December 29, 2023

RE: R+L Carriers Maintenance, 2381 Aztec Rd NE
Site Dimensional and Paving Plan
Engineer's/Architect's Stamp -no seal- (G16-D092)

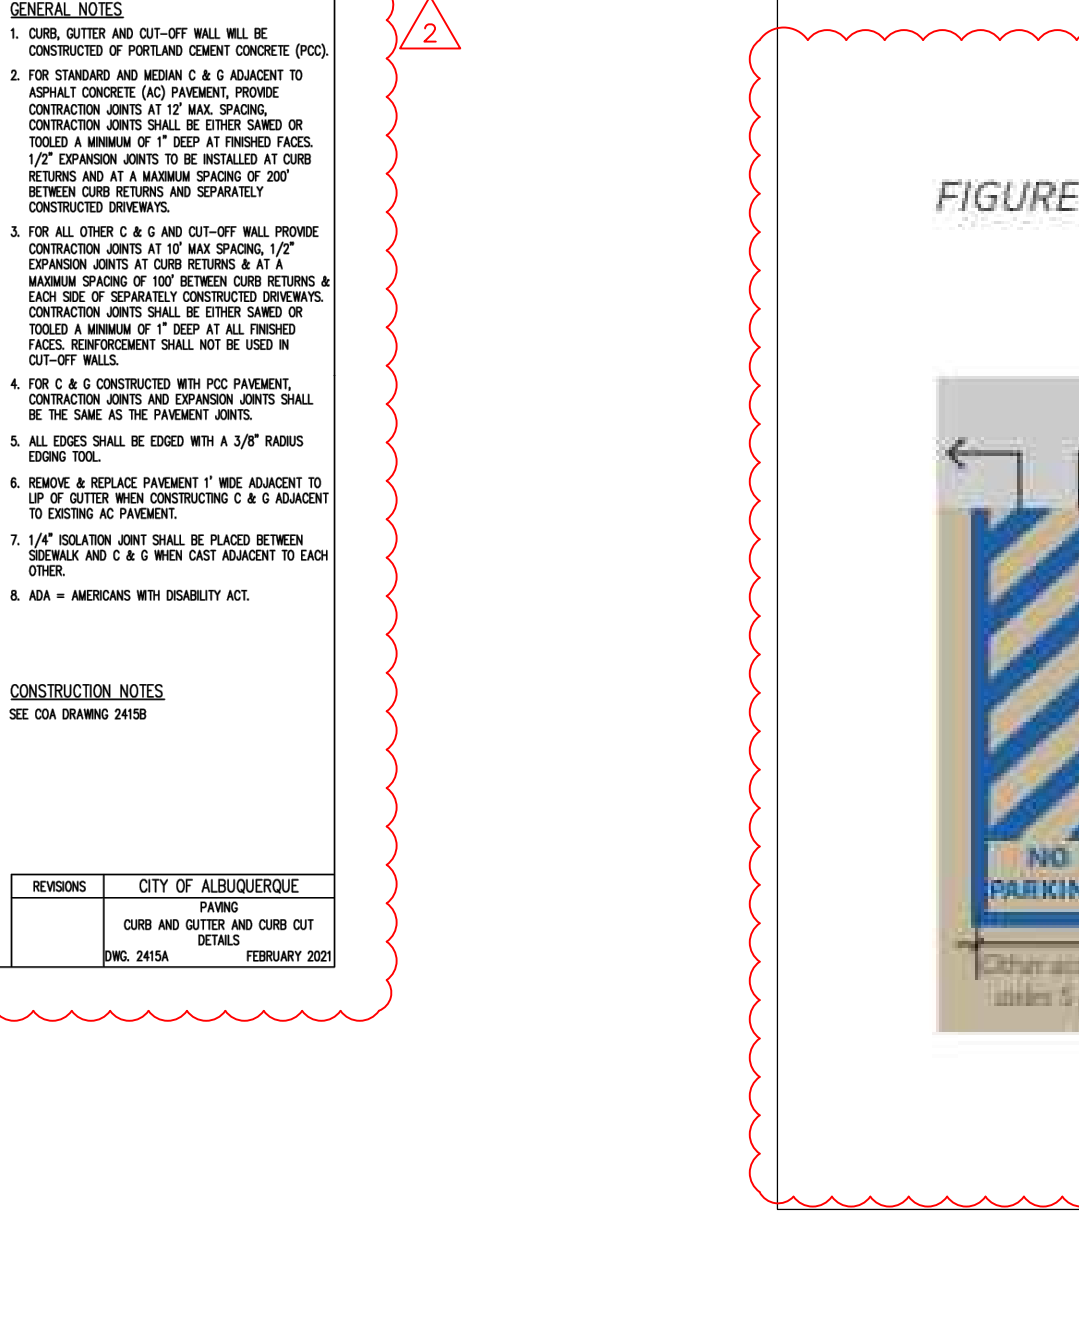
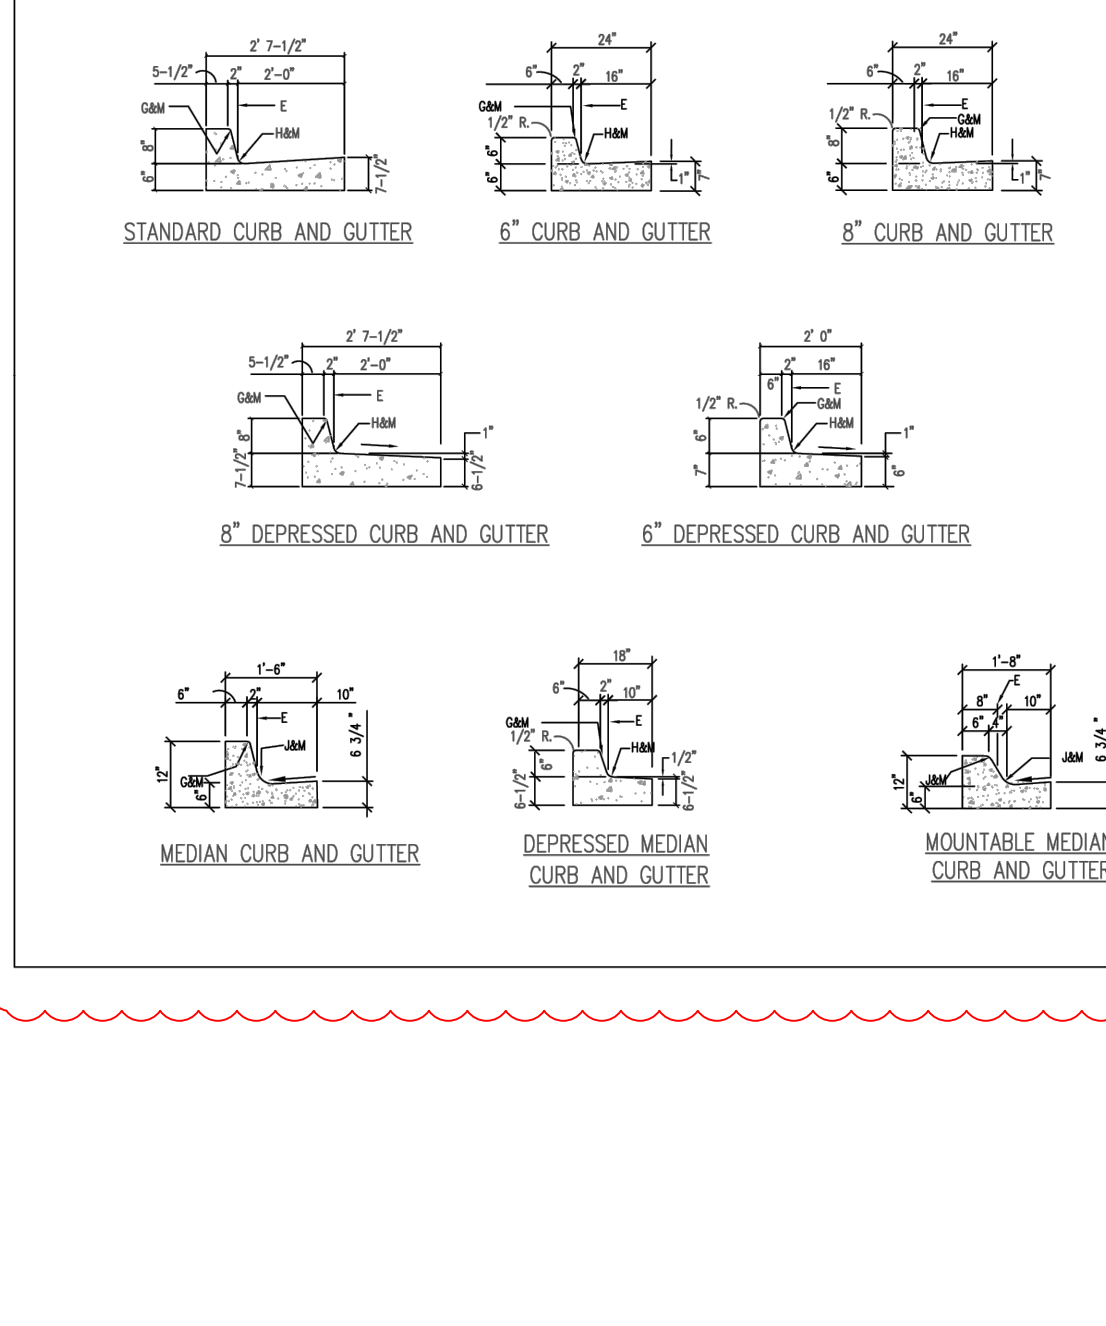
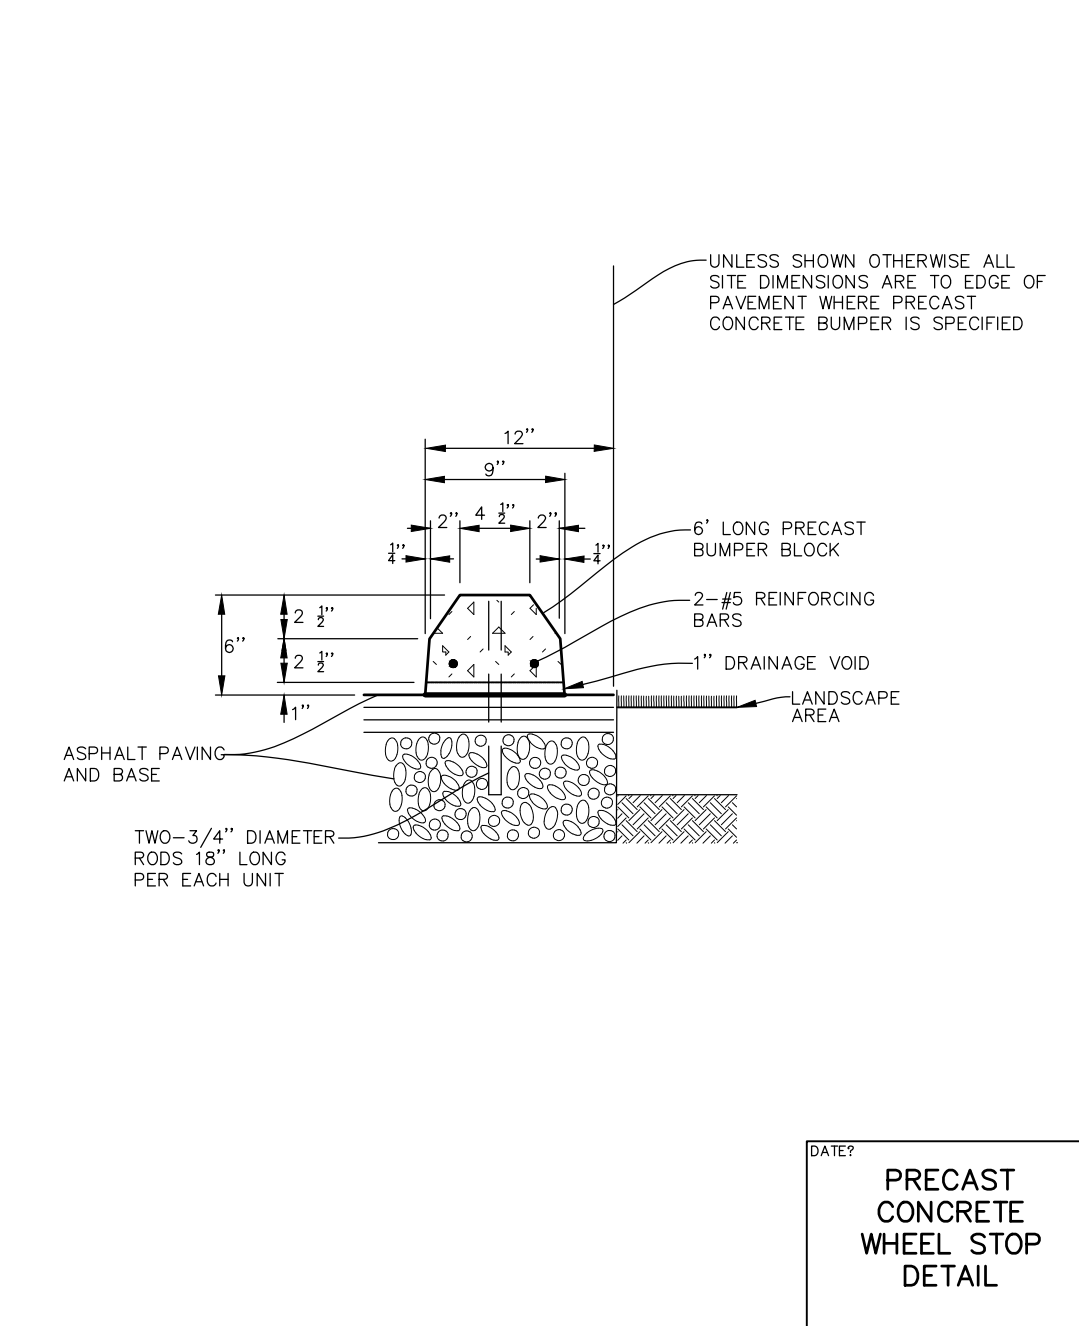
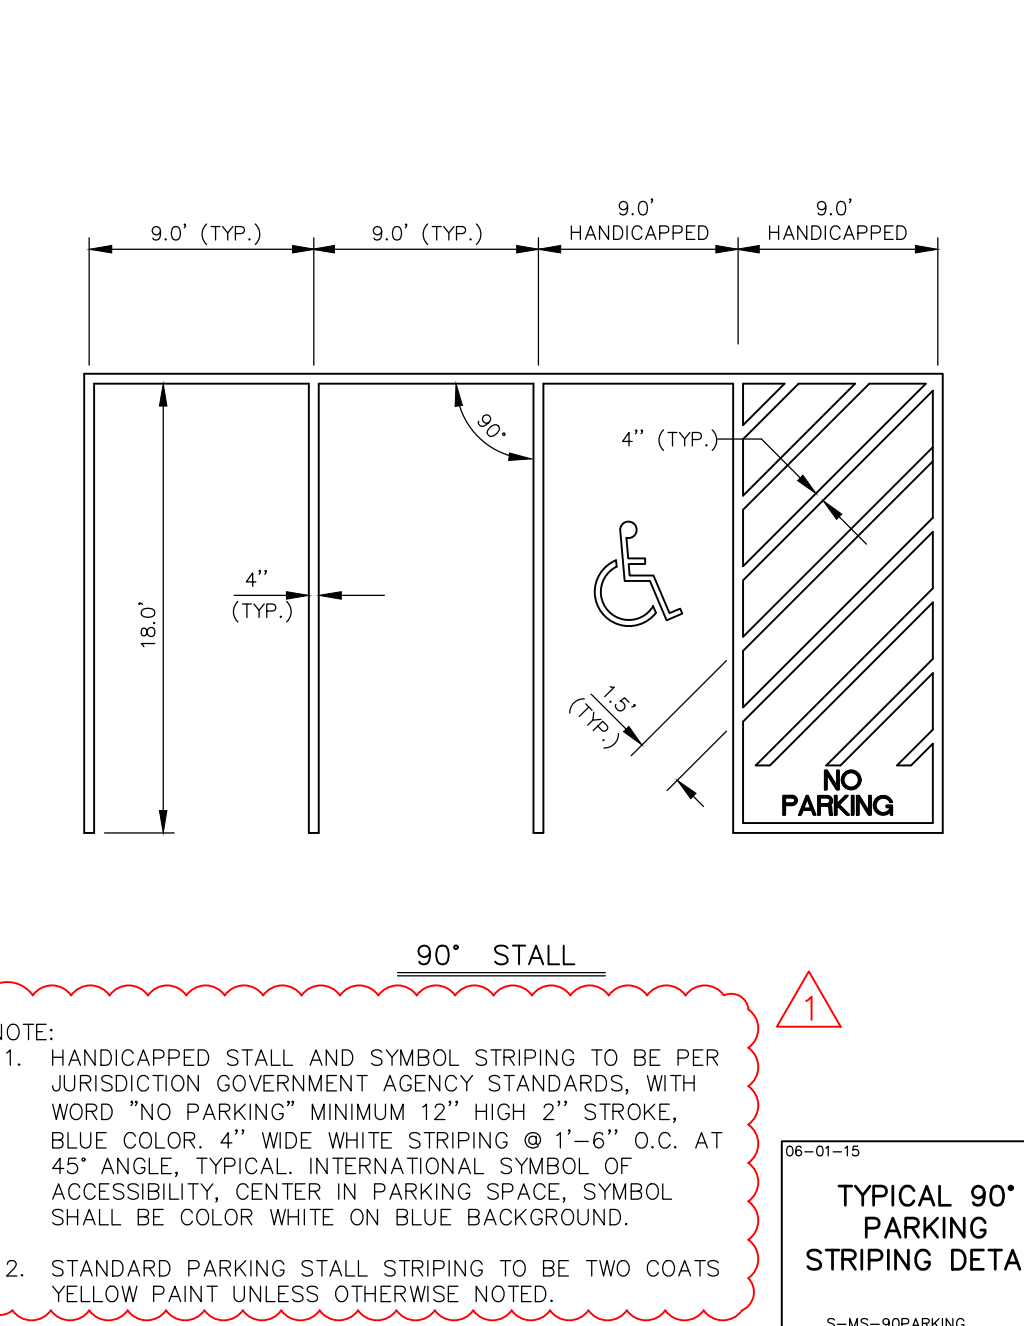
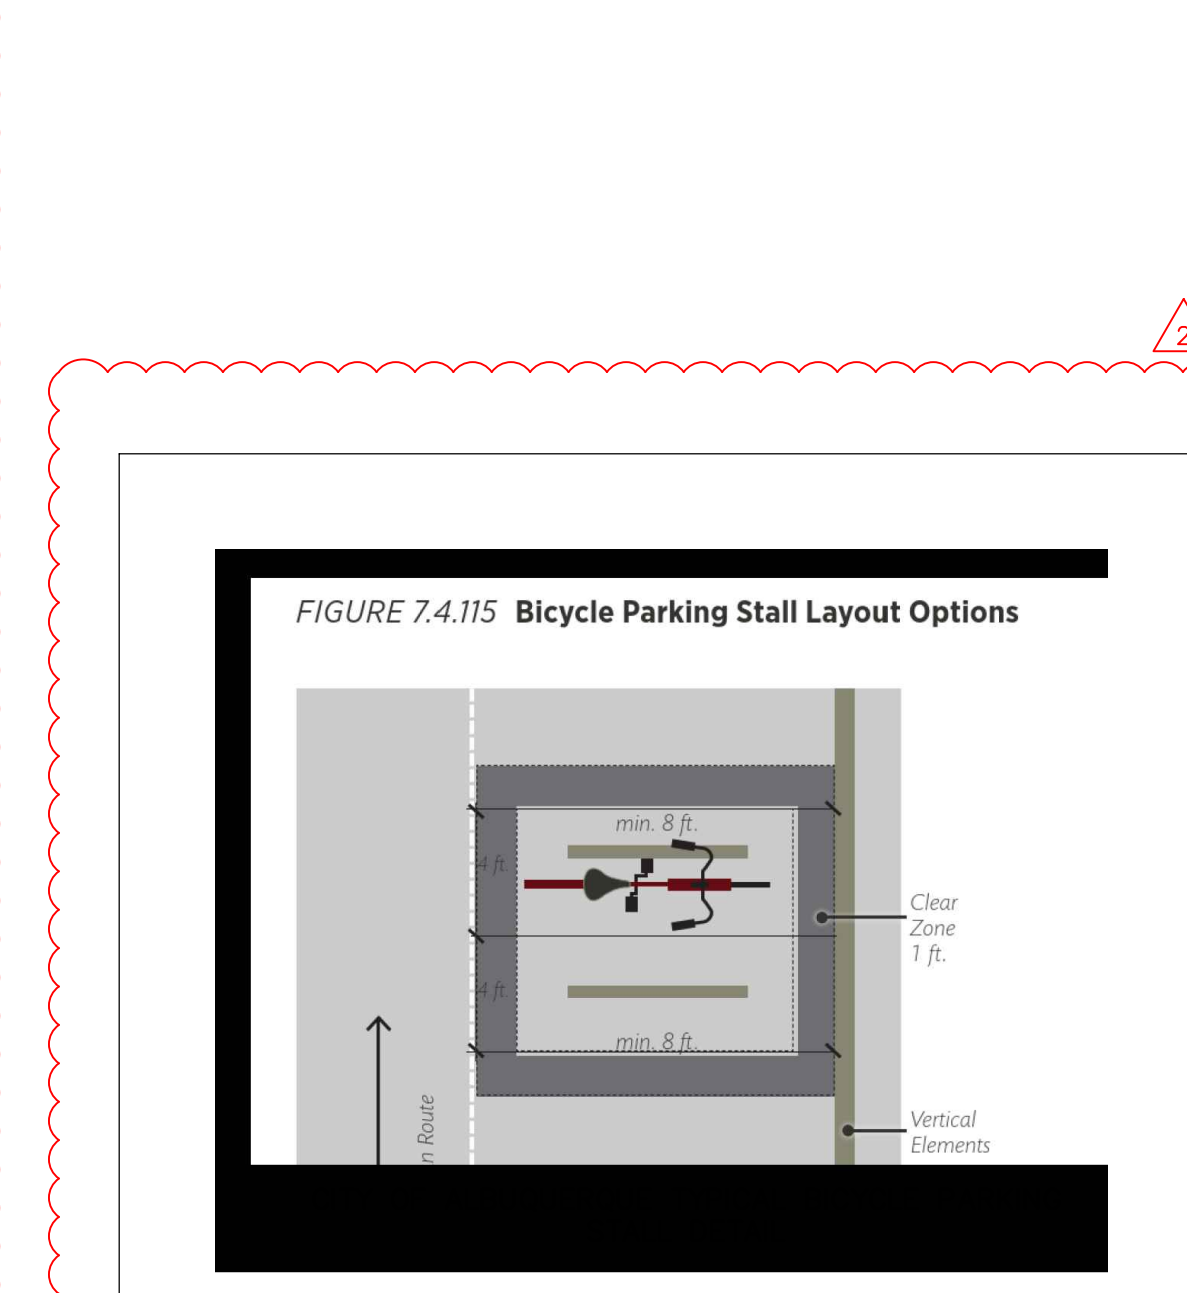
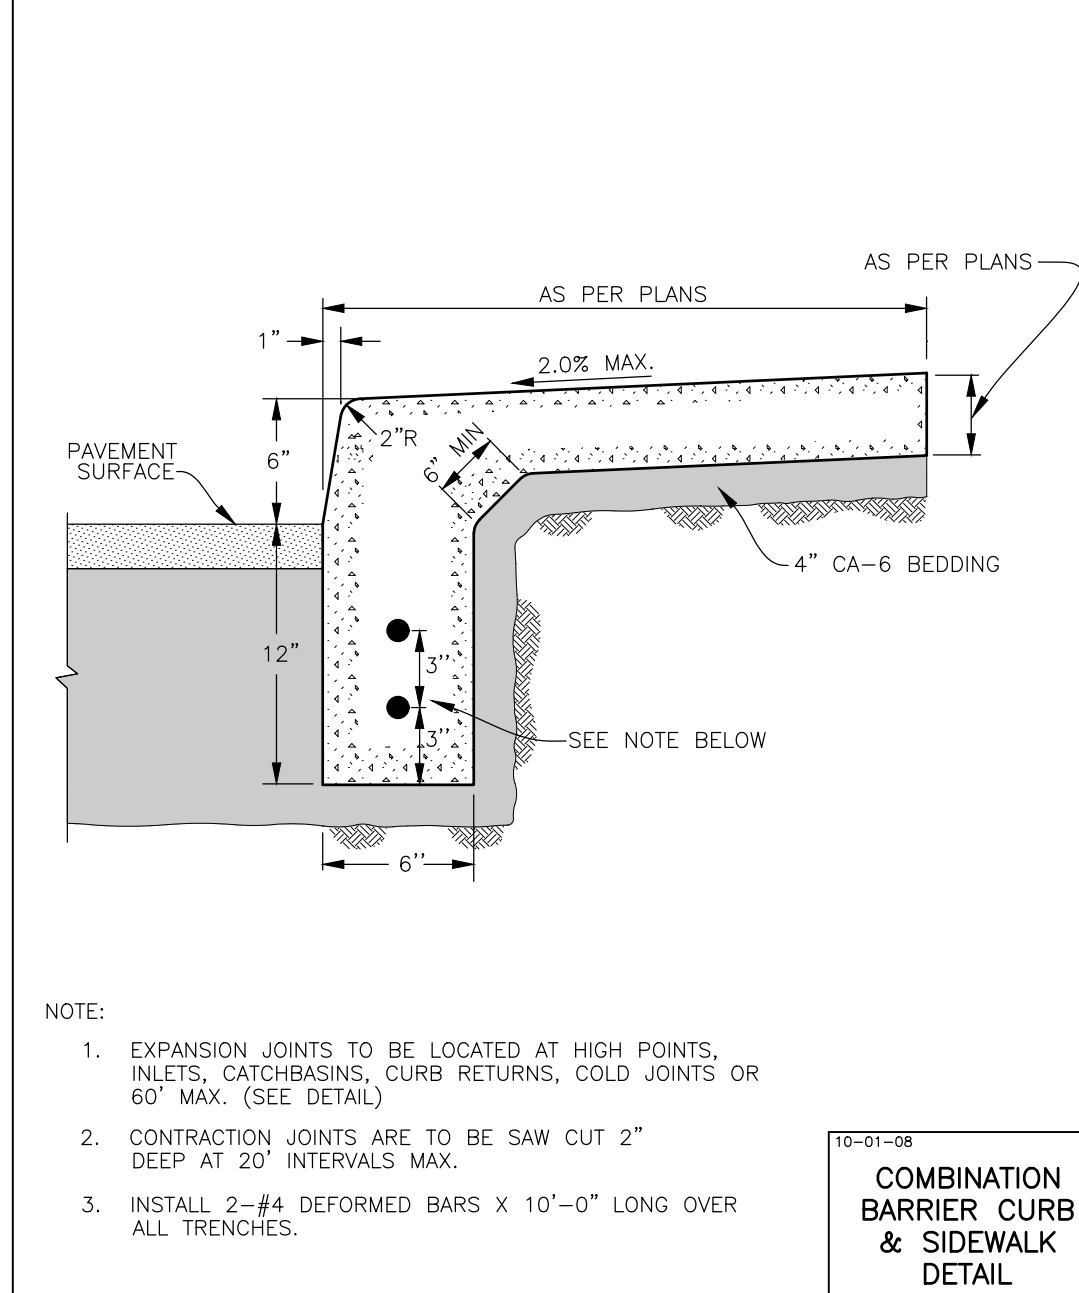
Response: Please refer to the Sheet 5 – Site Dimensional and Paving Plan of the Civil Engineering Plans.
3. Update the “Site data” table with the number of spaces required and the number of spaces provided. Per the IDO, for an 11,000 sq ft building for heavy vehicle maintenance; 11 parking spaces are required, including 1 van accessible ADA parking space. In addition, 1 motorcycle/space is required.

Response: The provided parking spaces quantity has been revised as required. The “Site Data” table has been updated accordingly.
4. I could not find 2 motorcycle spaces as shown in the table. Signage is required.

5. Provide dimensions and notes for pavement markings and signage for the handicap parking spaces.
Response: The required handicap parking space dimensions and signage have been added to the Site Plan. Additional detailed dimensions and notes for pavement markings for the handicap parking spaces are provided on the detail sheet #10.

7. Is there a sidewalk at the front of the building? If so, provide a dimension for the width.
Response: The sidewalk at front of the building is 5' wide, the dimension has been added.

Response: The quantity of the motorcycle parking spaces has been updated, there will be (1) motorcycle space provided. The required sign has been added.
